Application No: EP/56/21/HH
Site Address: 33 The Ridings East Preston BN16 2TW
Description of works: Erection of single storey side/rear extension and hip to gable loft conversion with 1 x front and side dormer

This council's Planning & Licensing Committee has considered this Application electronically and would like to raise the following objections to this Application.

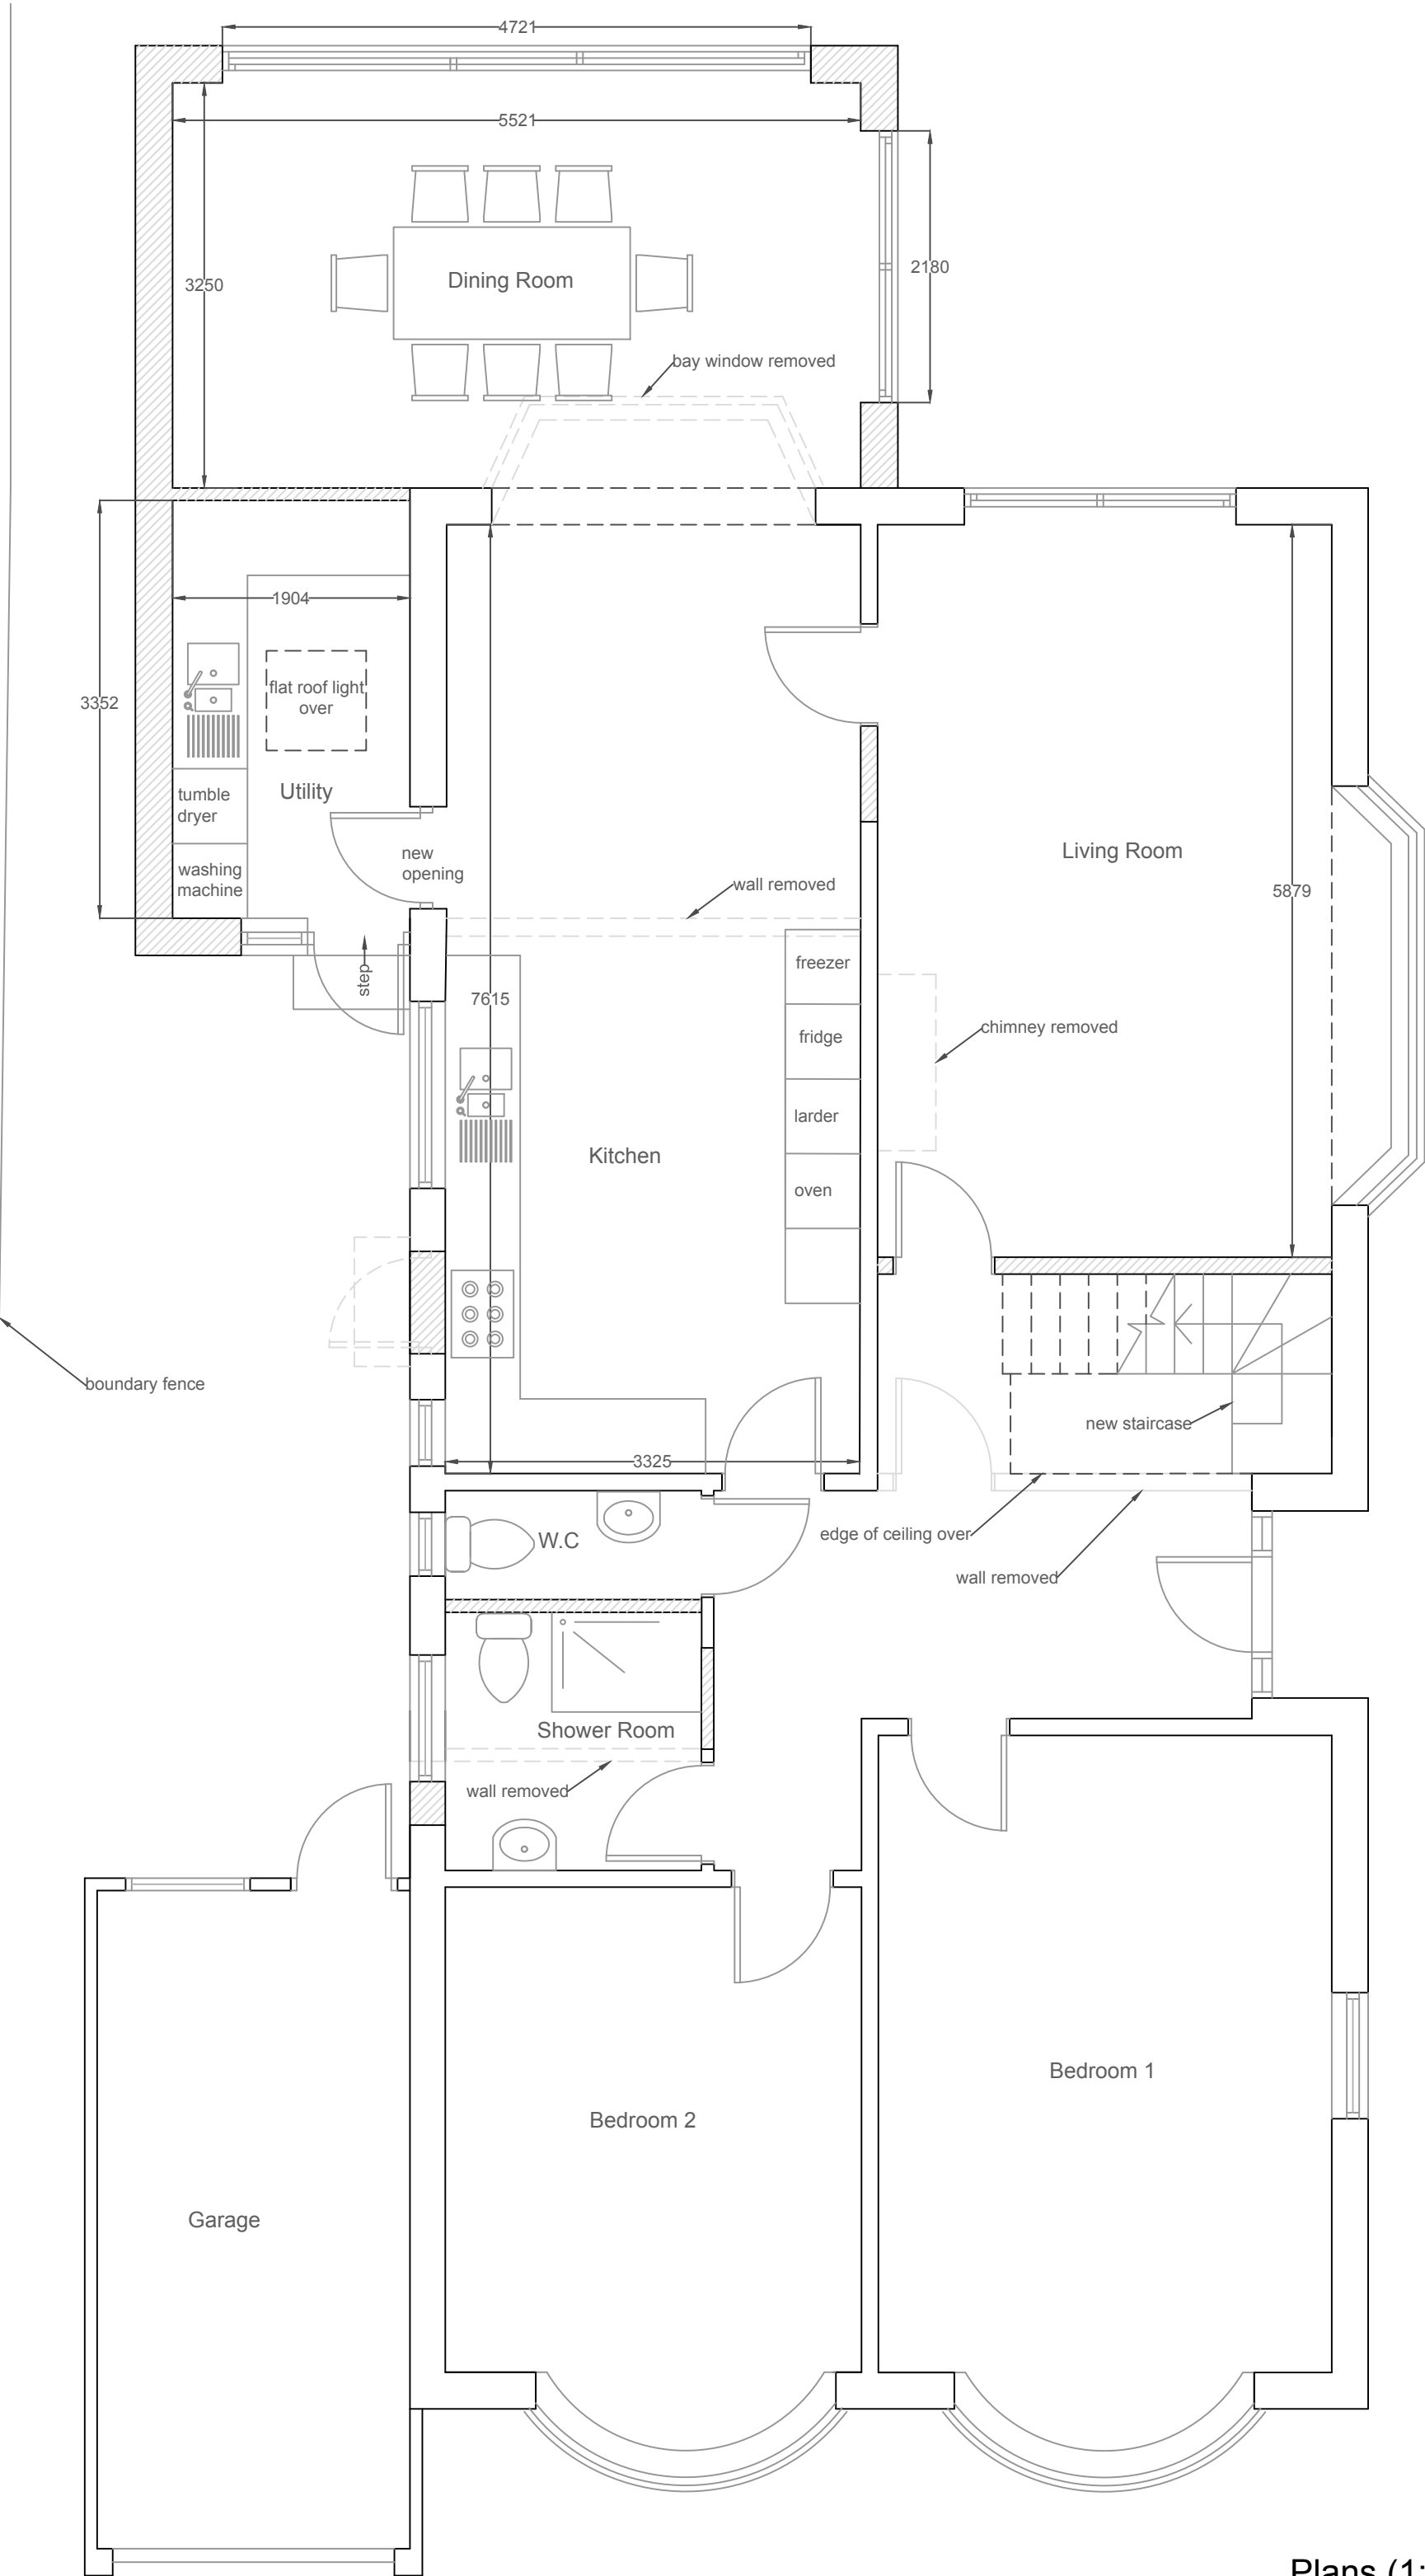
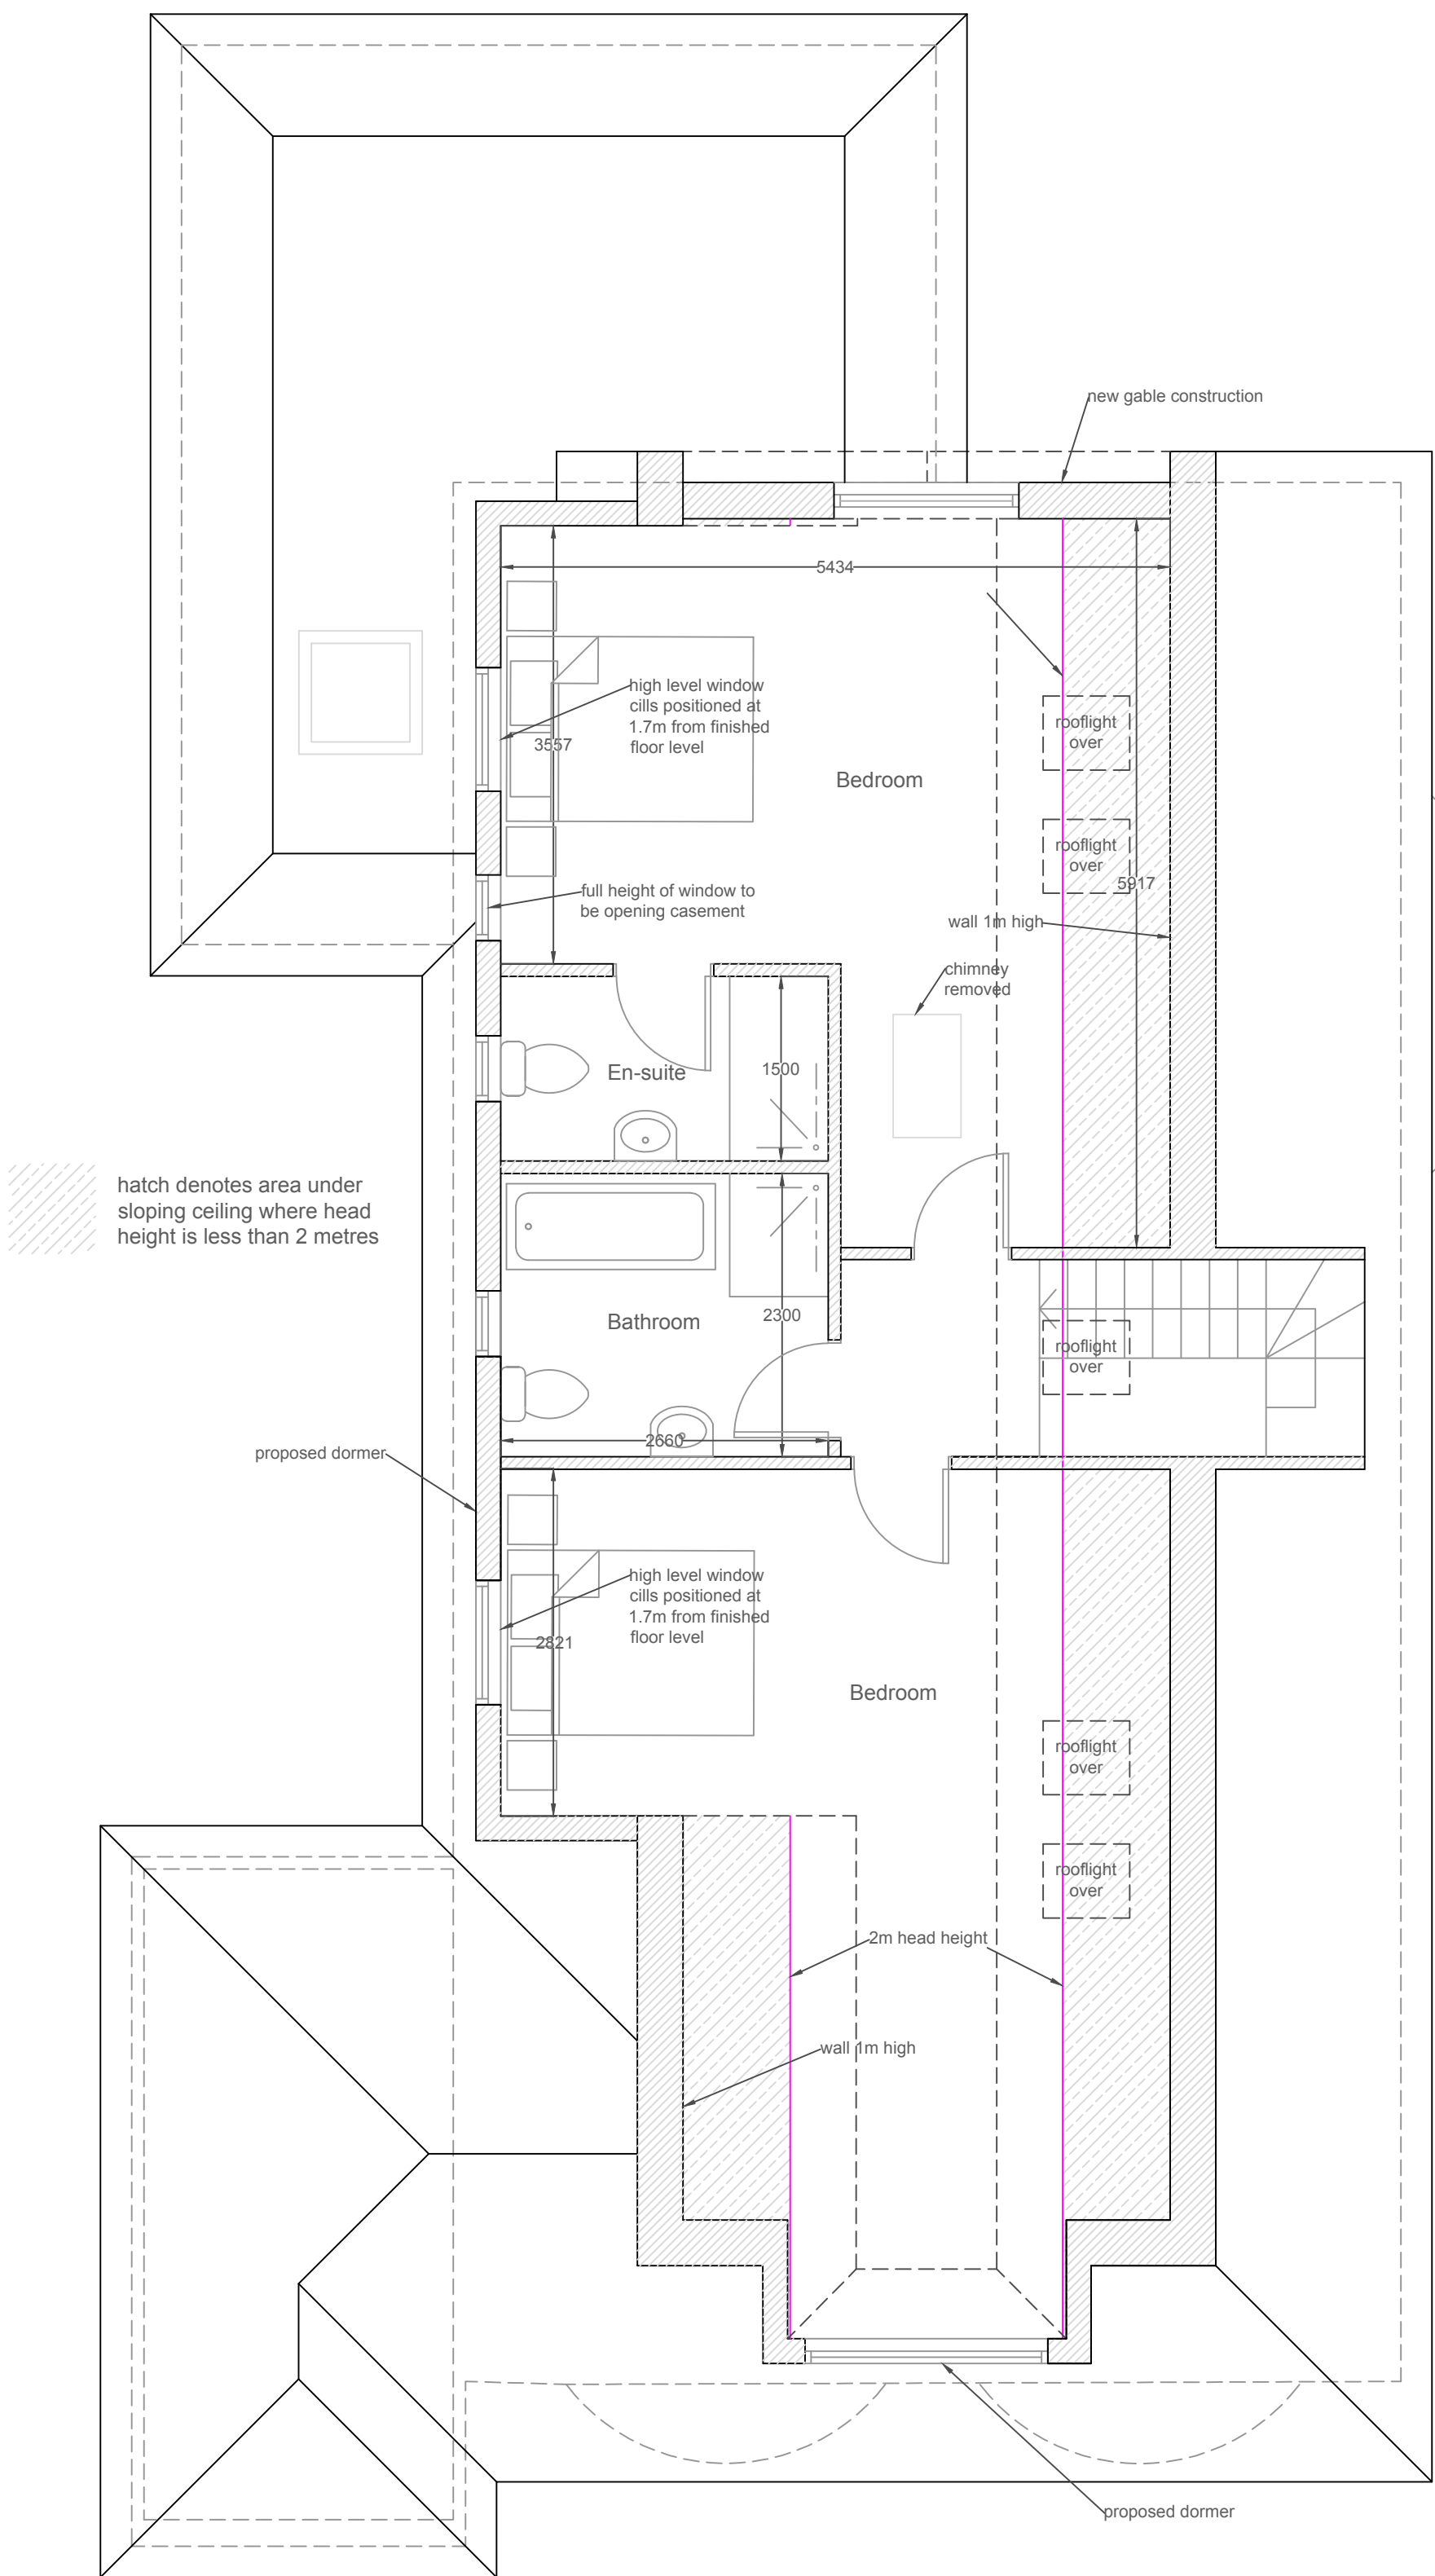
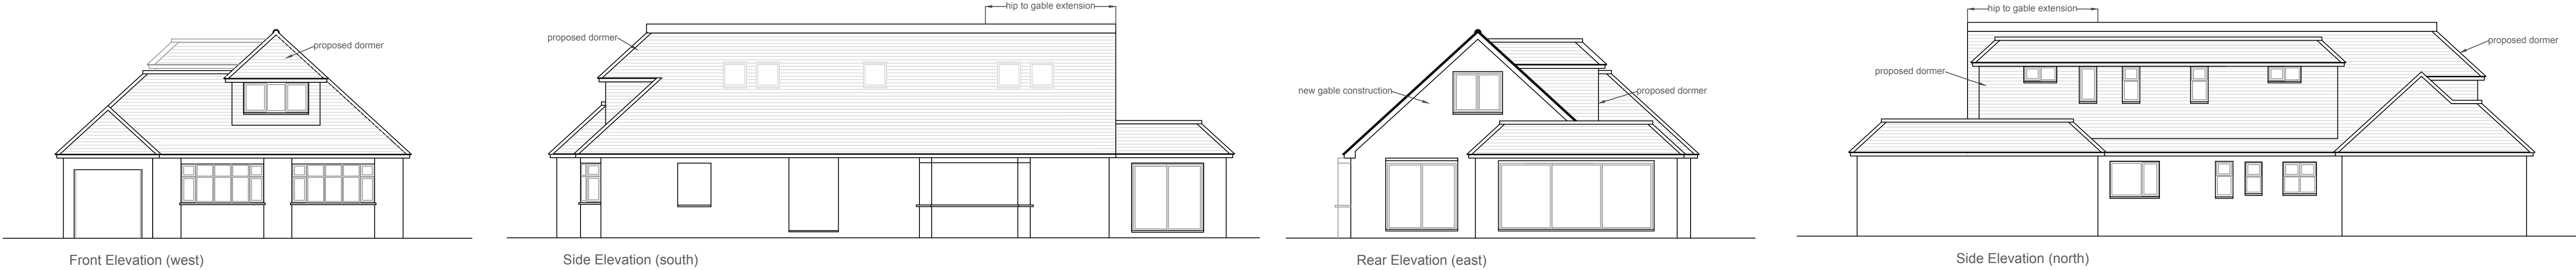
The property is one of a line of smaller bungalows in this area. The committee felt the proposed development on the side of the property, so close to the northern boundary could be considered overdevelopment of the plot. The committee was also concerned this proposal will spoil this attractive pair of bungalows resulting in an unbalanced streetscene.

The windows on the northern elevation of the proposed dormer risk unacceptable overlooking directly into rooms in the neighbouring property, a concern already eloquently expressed by the owners of that property. Should the District Council be minded to give approval to this dormer and the windows it contains, could a Condition be considered to have those windows obscurely glazed at all times and with limited opening? It is arguable the proposed dormer is also not terribly subservient to the main roof.
